Environmental Health Division
1675 W. Garden of the Gods Road
Suite 2044
Colorado Springs, CO 80907
(719) 578-3199 *phone*
(719) 578-3188 *fax*
www.elpasocountyhealth.org

Walden Preserve 2, Filing No. 4, SF-18-034

Please accept the following comments from El Paso County Public Health regarding the proposed 45.27 acre, 23 residential lot development project referenced above:

POND B PLAN

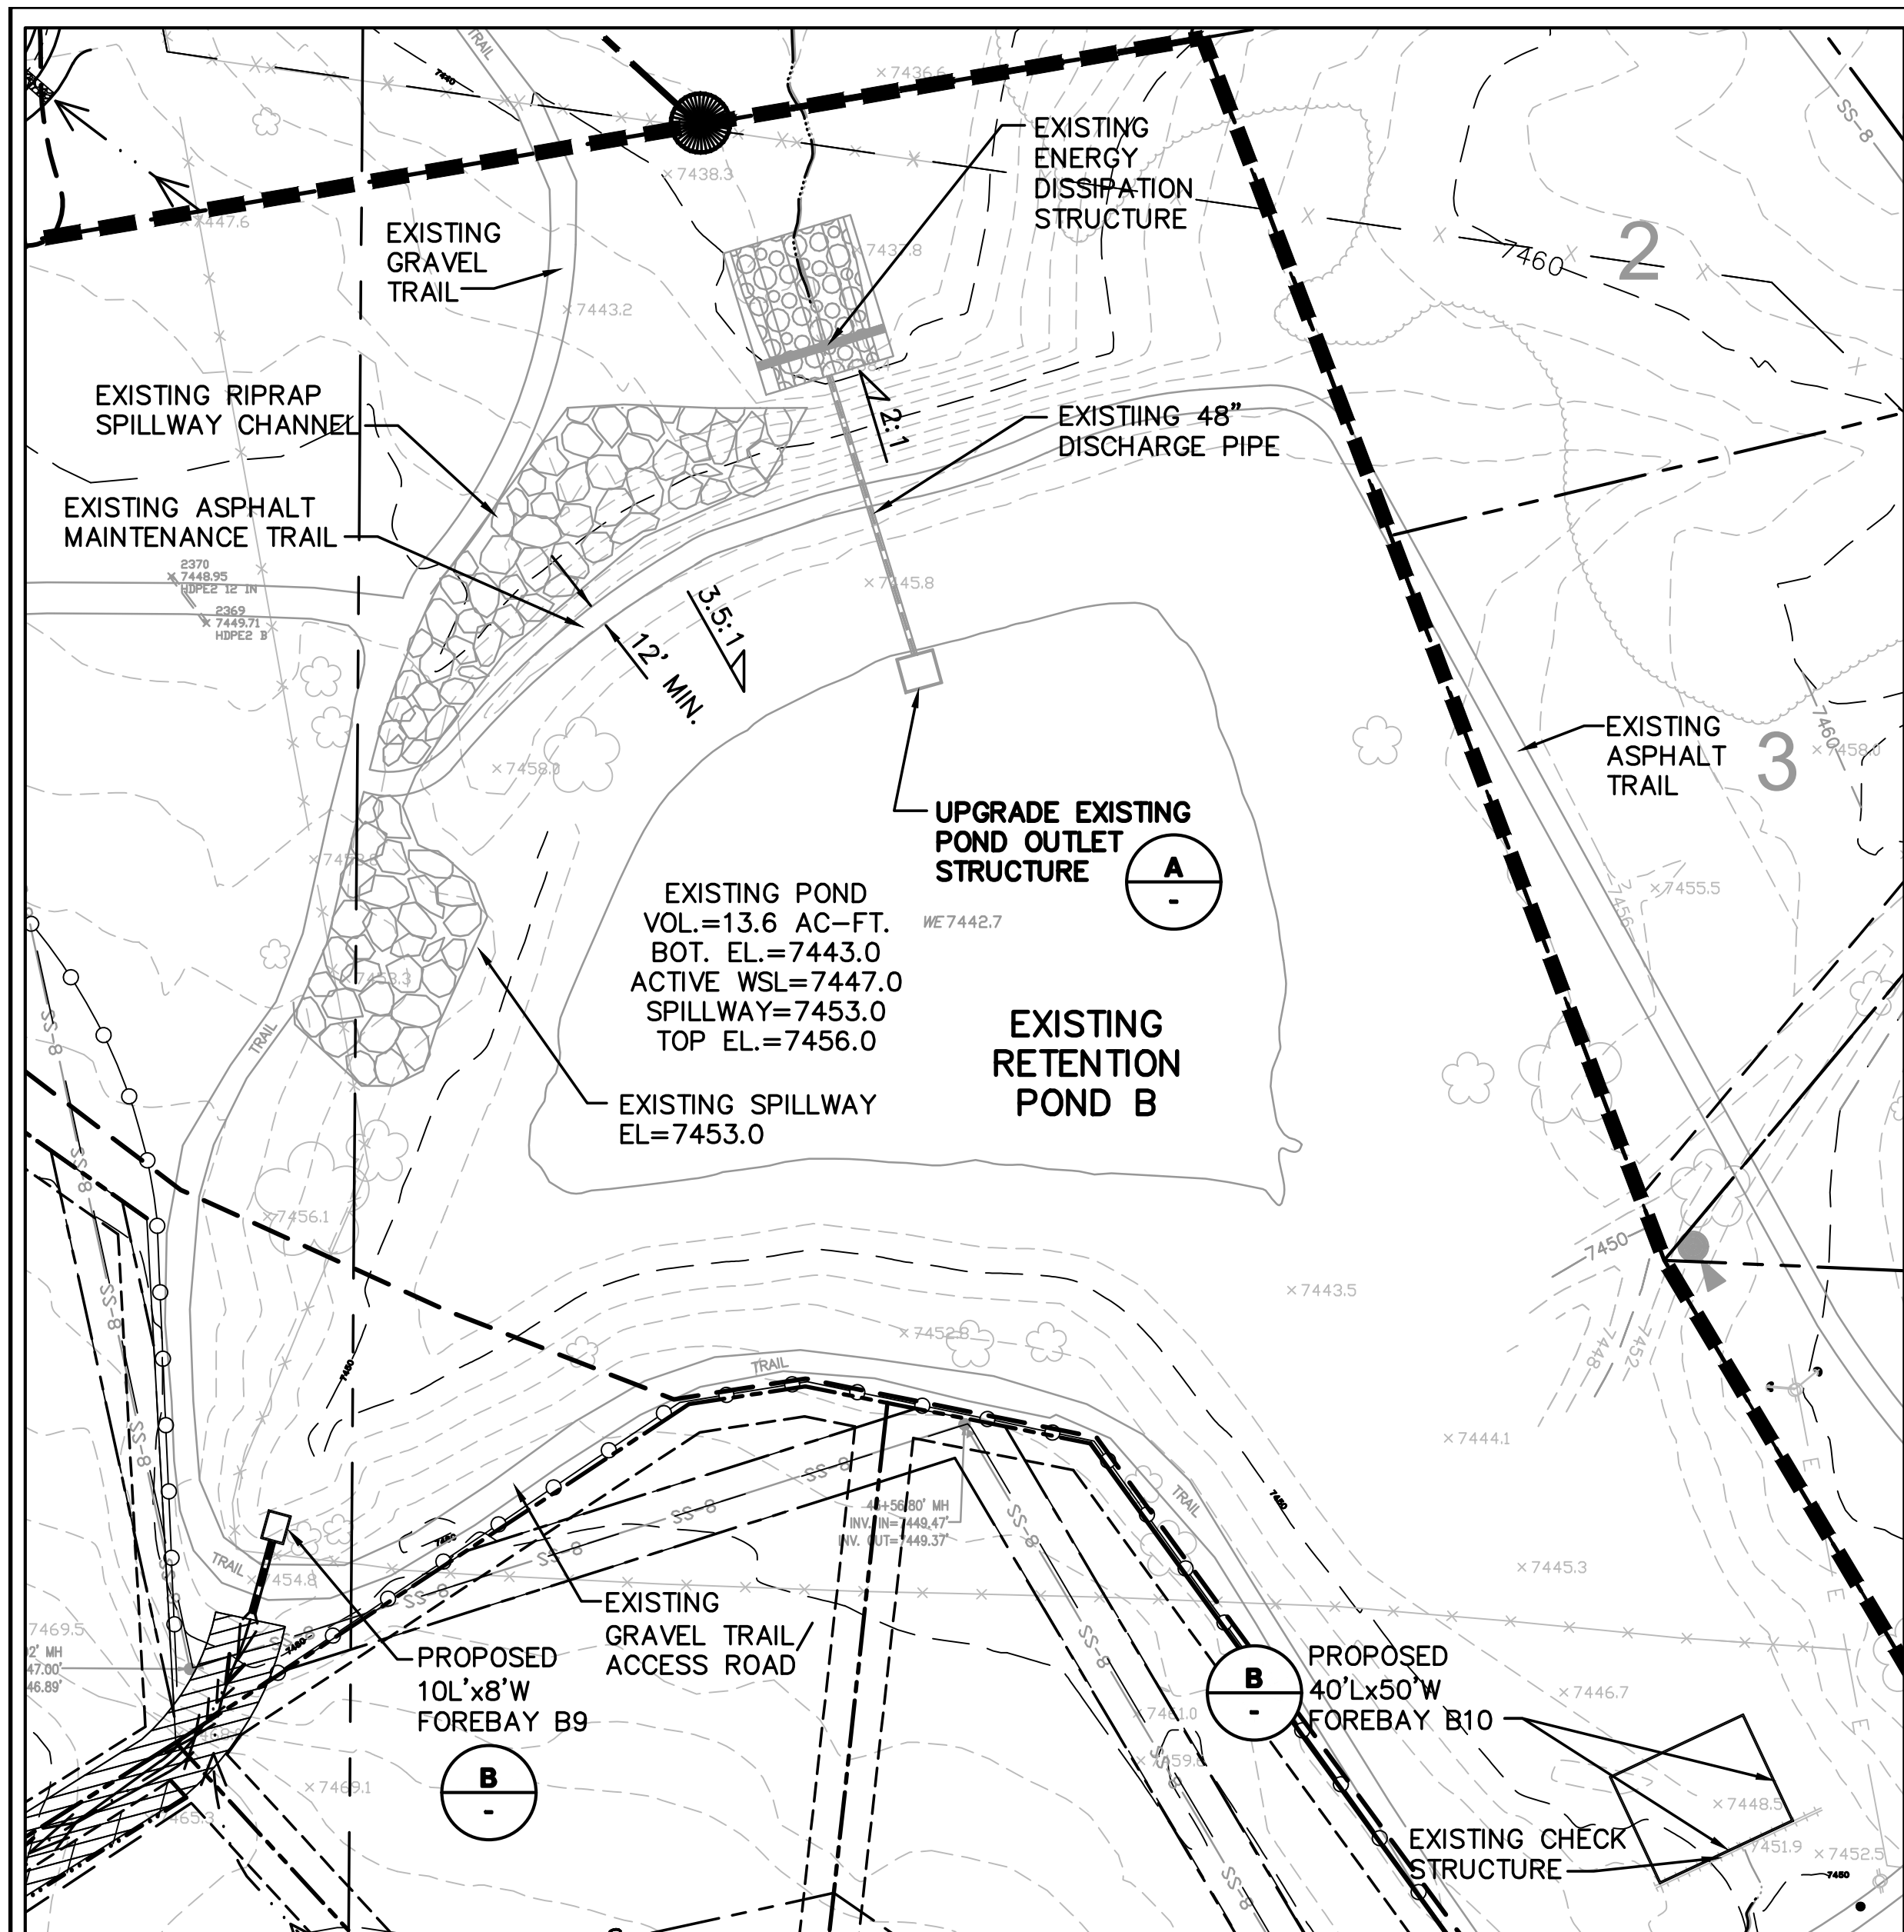
- The water quality detention basins must have mosquito control responsibilities included as a part of the maintenance plan to help control mosquito breeding habitat and minimize the potential for West Nile Virus.
